MEMORANDUM

DATE: July 21, 2021

SUBJECT: PUDSP-20-005 – Falcon Meadows at Bent Grass (with EGP)
Sixth Submittal

Engineering Division

**U2.1**  
 Sheet 11 of 21

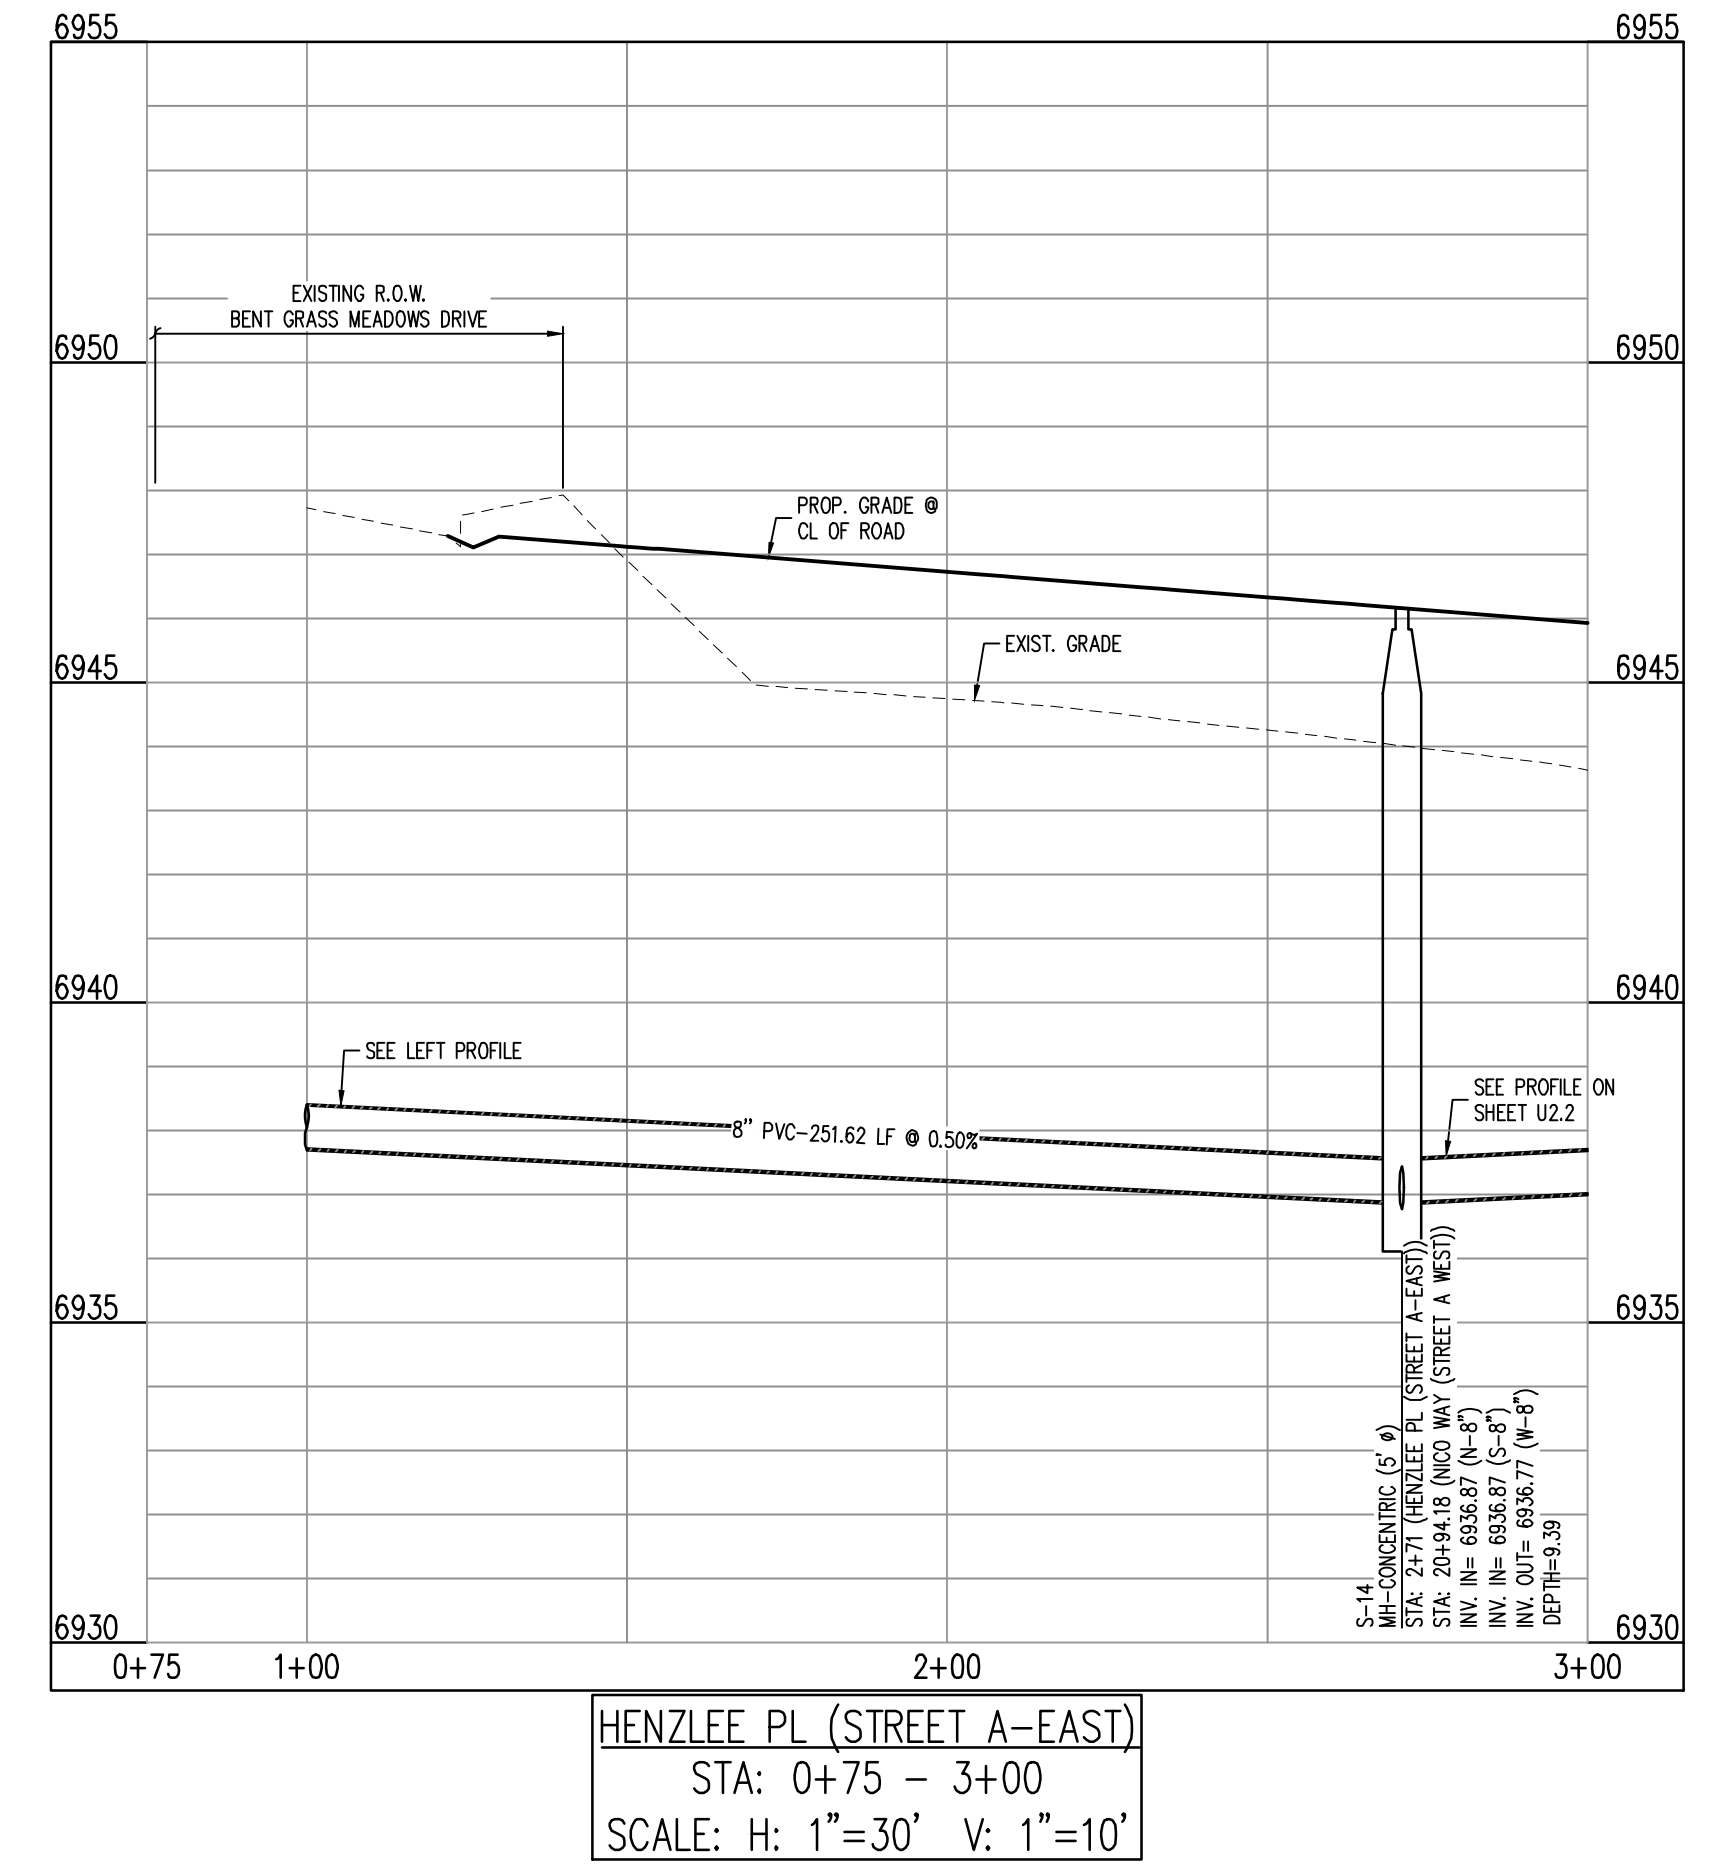
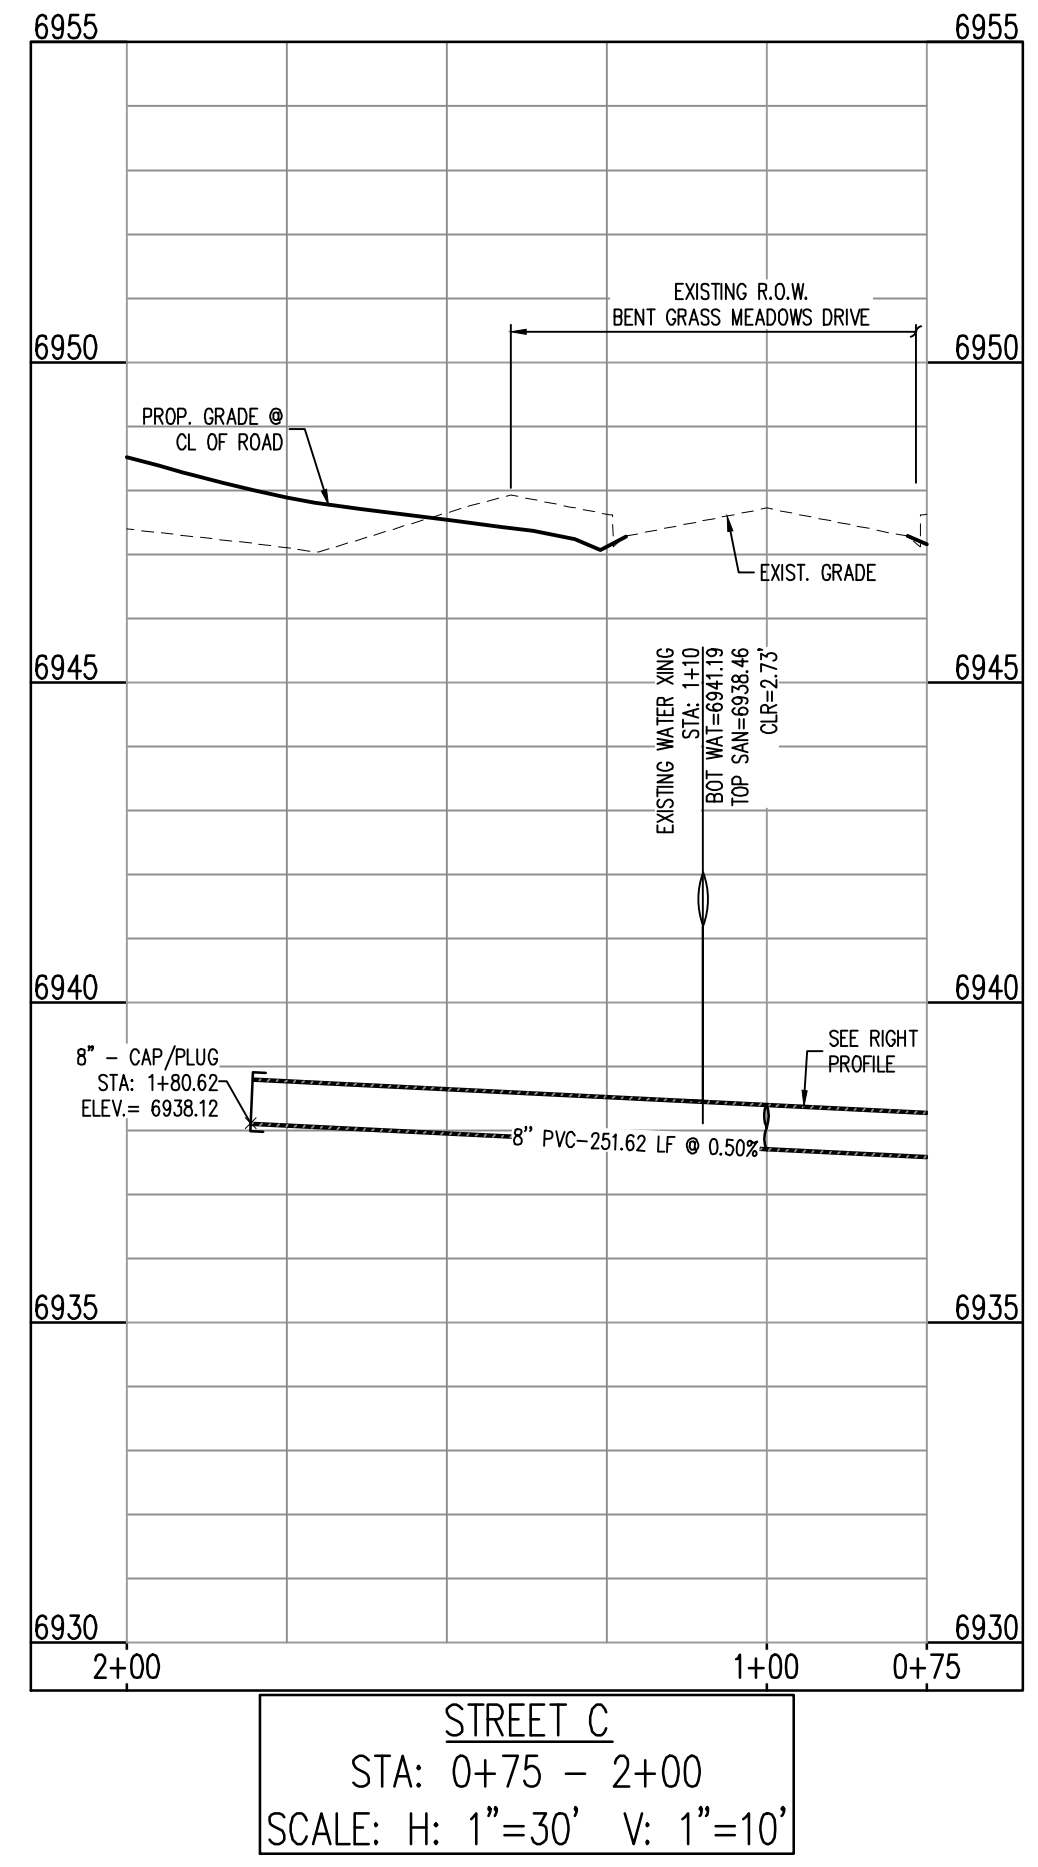
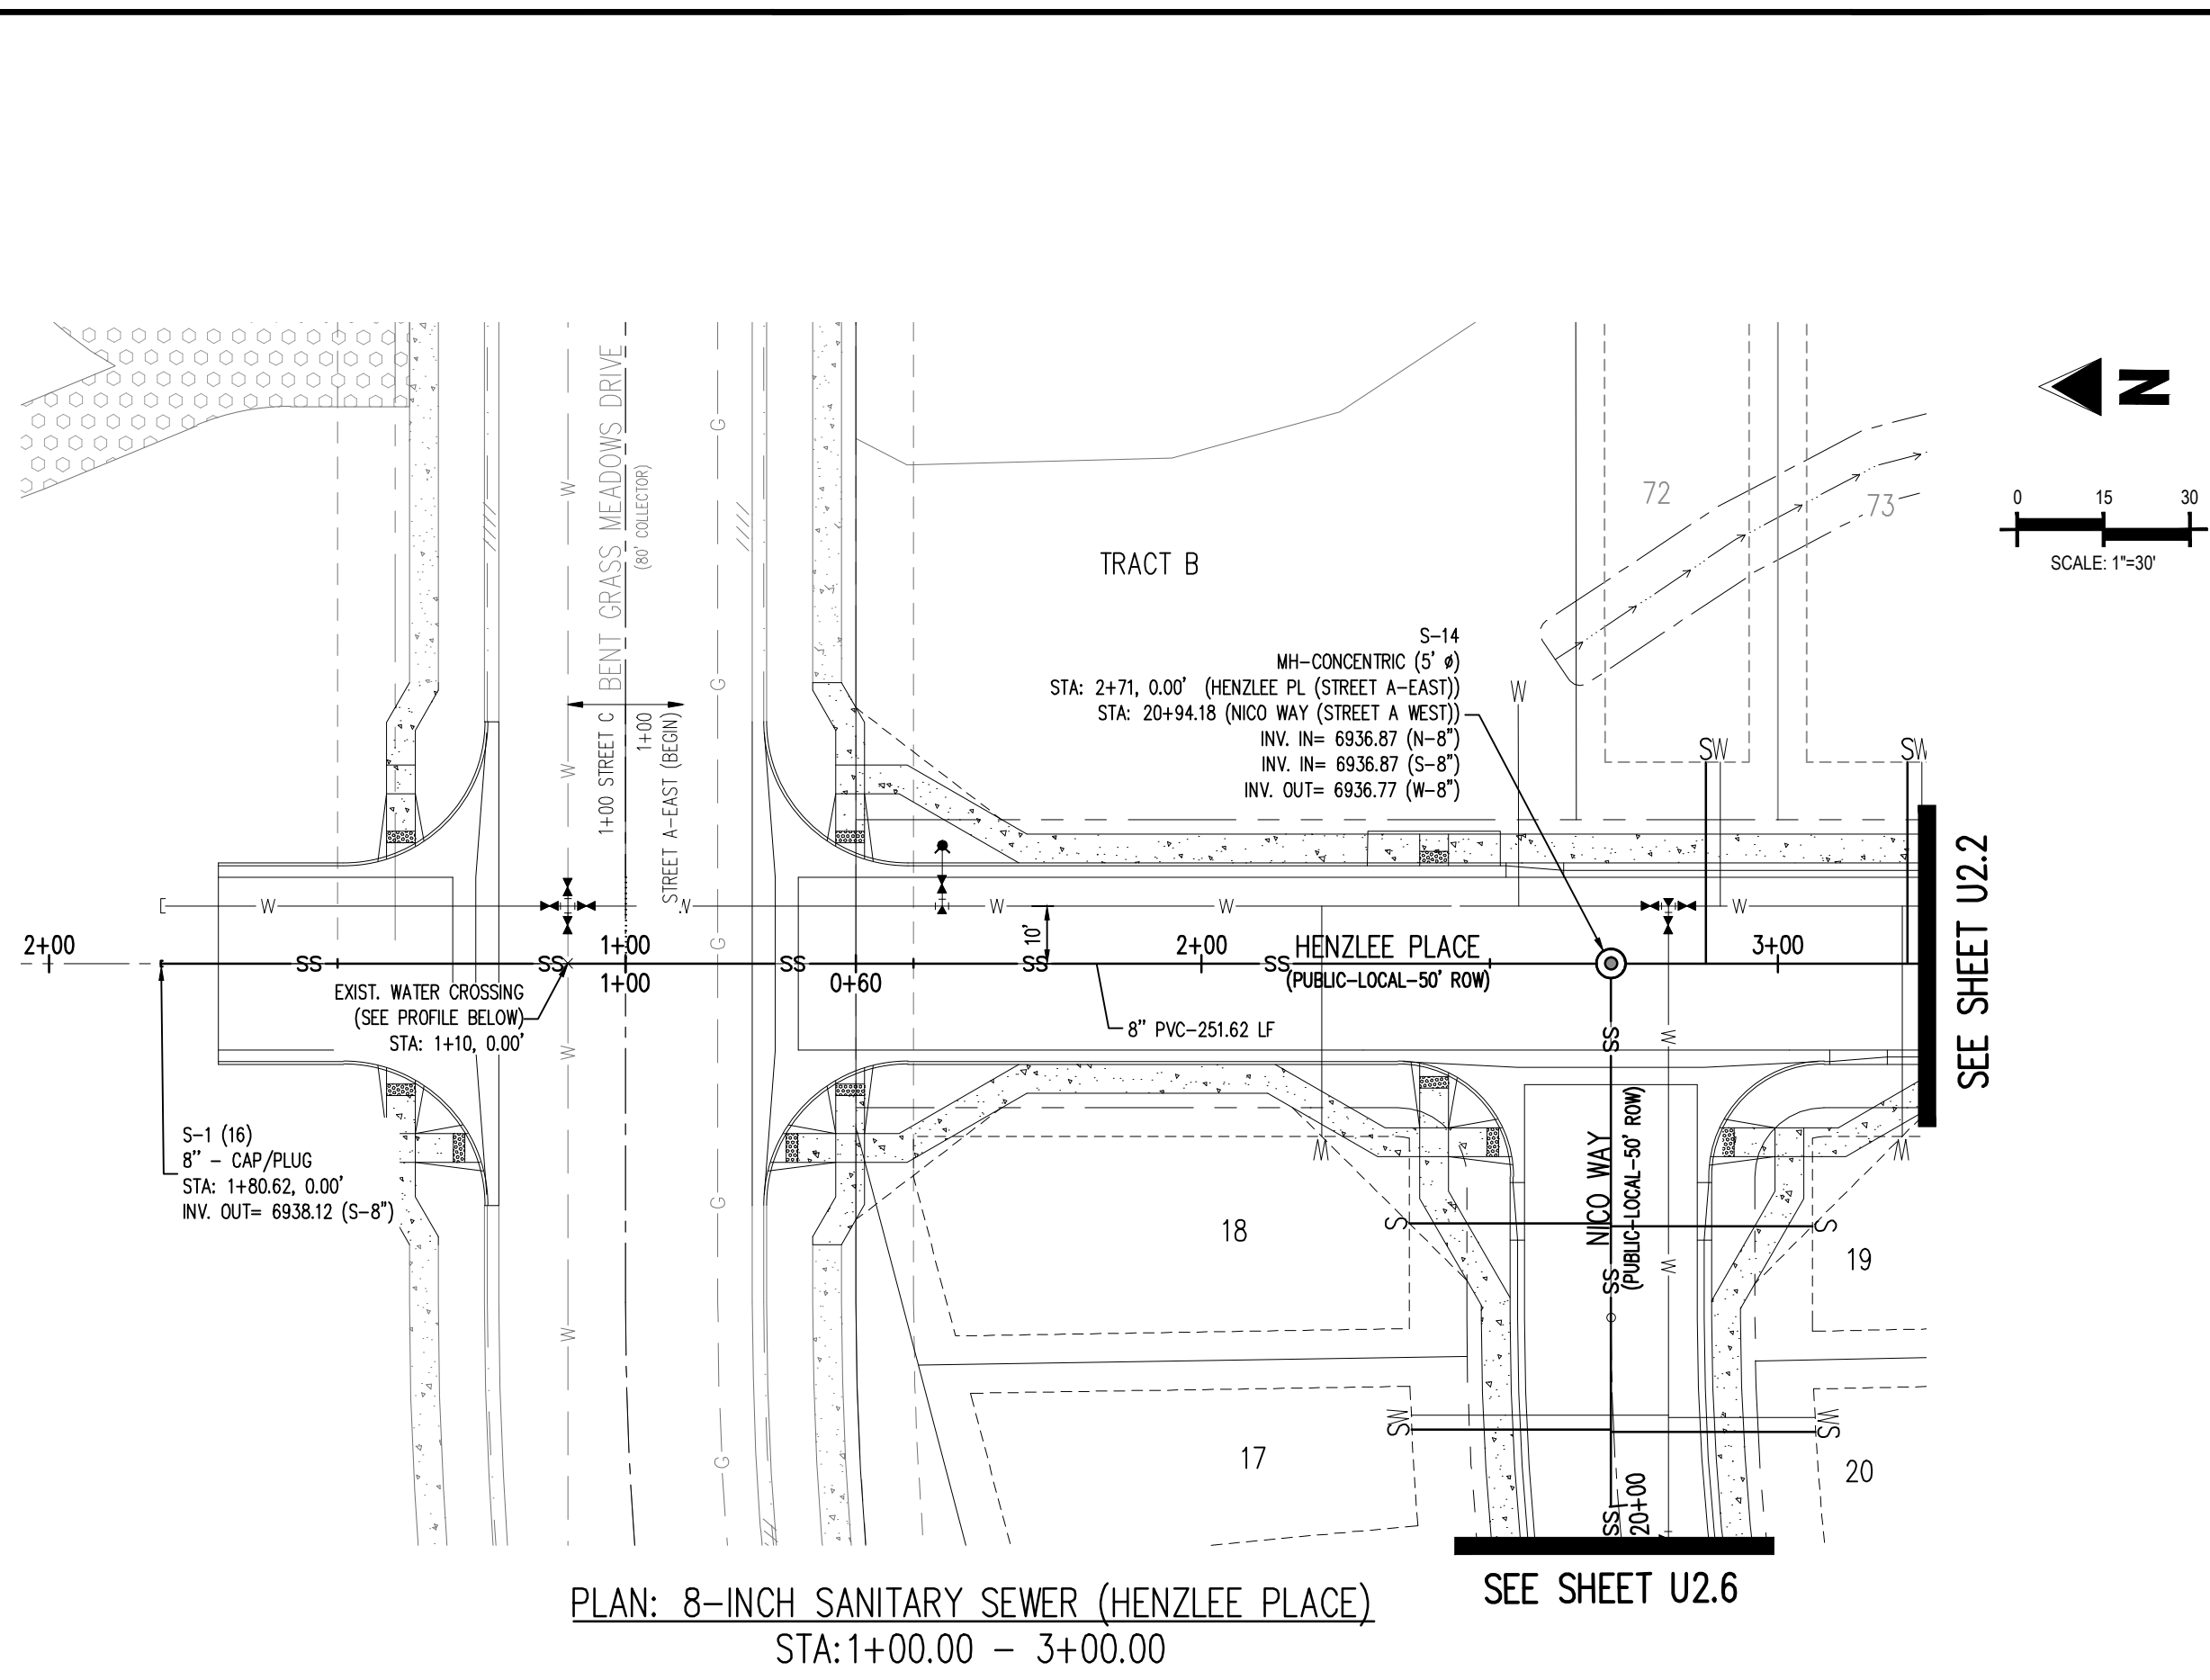
1. See redlines. **Partially resolved; see remaining/updated redlines.**
